RE: Narrabri Shire Council Submission – Wee Waa High School (SSD-21854025)

WEE WAA HIGH SCHOOL

SSD-21854025

SUBMISSION REPORT

FIGURE 6 - STORMWATER CHANNEL LOCATIONS

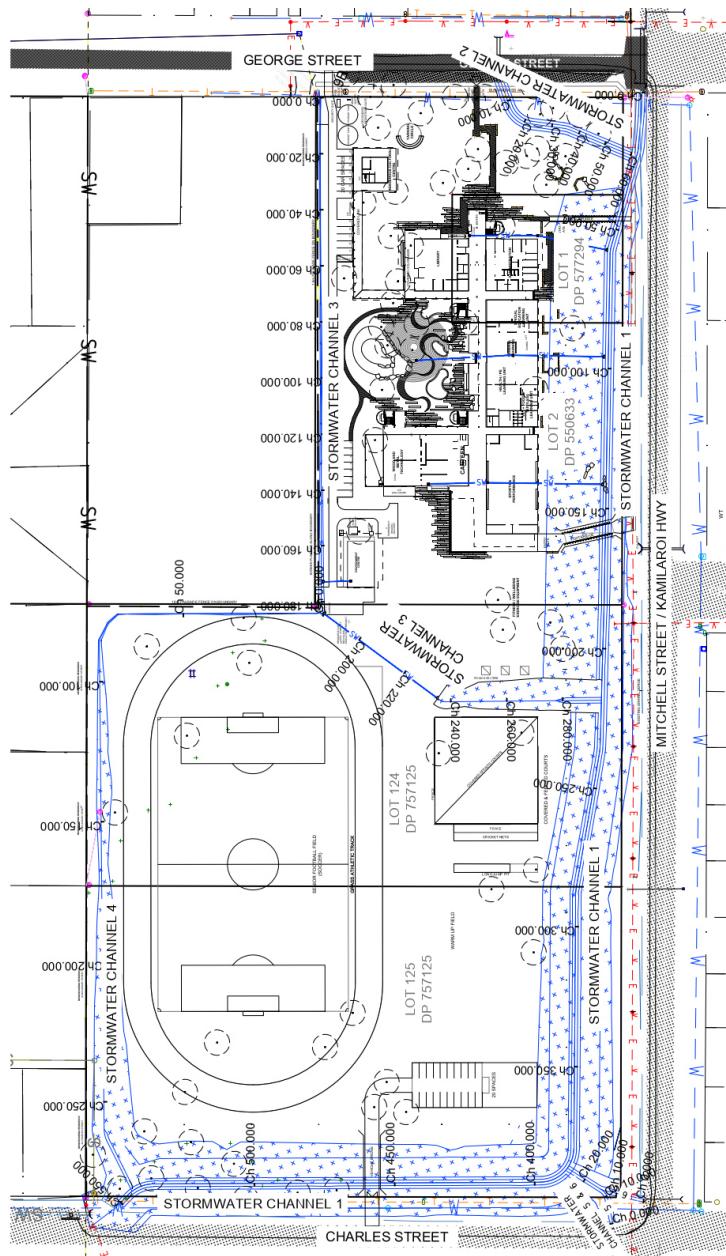
- **Safety in design:** A safety in design assessment of the proposed drainage works has not been provided. In particular, a risk assessment should have been undertaken for the proposed drainage channel (located adjacent to a school) and the Charles Street culverts.

The report defines the drainage channel as a floodway under the criteria given in the NSW Floodplain Development Manual (DIPNR, 2005) and with a H4 flood hazard vulnerability category under the Australian Disaster Resilience Guidelines (AIDR, 2017).

A H4 flood hazard is unsafe for people. The proposed channel significantly changes the existing risk from a H2 hazard category (generally safe for people) to an unsafe hazard category (H4). It also increases the number of vulnerable population (children) next to the unsafe area, which has increased the potential consequences. No measures have been provided to mitigate the increased risk (or consequence).

More importantly, the proposed culvert upgrade along Charles Street, as designed, is an extreme hazard. The likelihood of a child either falling into the channel (or playing in the channel) would be relatively high during a summer storm event. The likelihood of that child being sucked into the Charles Street culverts would also be relatively high given that velocities appear to increase as the flows drain into the culverts. The culvert invert is also located at the same bed level as the channel, meaning it is directly accessible. The consequence of a child or even an adult entering the culvert would be extreme as they would be unlikely to survive being sucked along a 1350 mm pipe flowing full for over 200m.

The proponent has not demonstrated how this extreme risk can be managed.

It is possible that exclusion screens could be used to reduce the likelihood of a person entering the pipe. However, the maximum clear spacing between the exclusion bars would significantly increase the likelihood of a blockage, which has the potential to increase flooding of neighbouring properties. Exclusion bars would also be required on the downstream side.

Notwithstanding the above, the proponent has **not** adequately assessed the safety aspects of the proposed works. This is a significant shortcoming of the assessment. The proposed drainage channel would increase the safety risk from low to high. The proposed Charles Street culverts would increase the safety risk from low to extreme. The proponent needs to demonstrate how these risks can be managed.
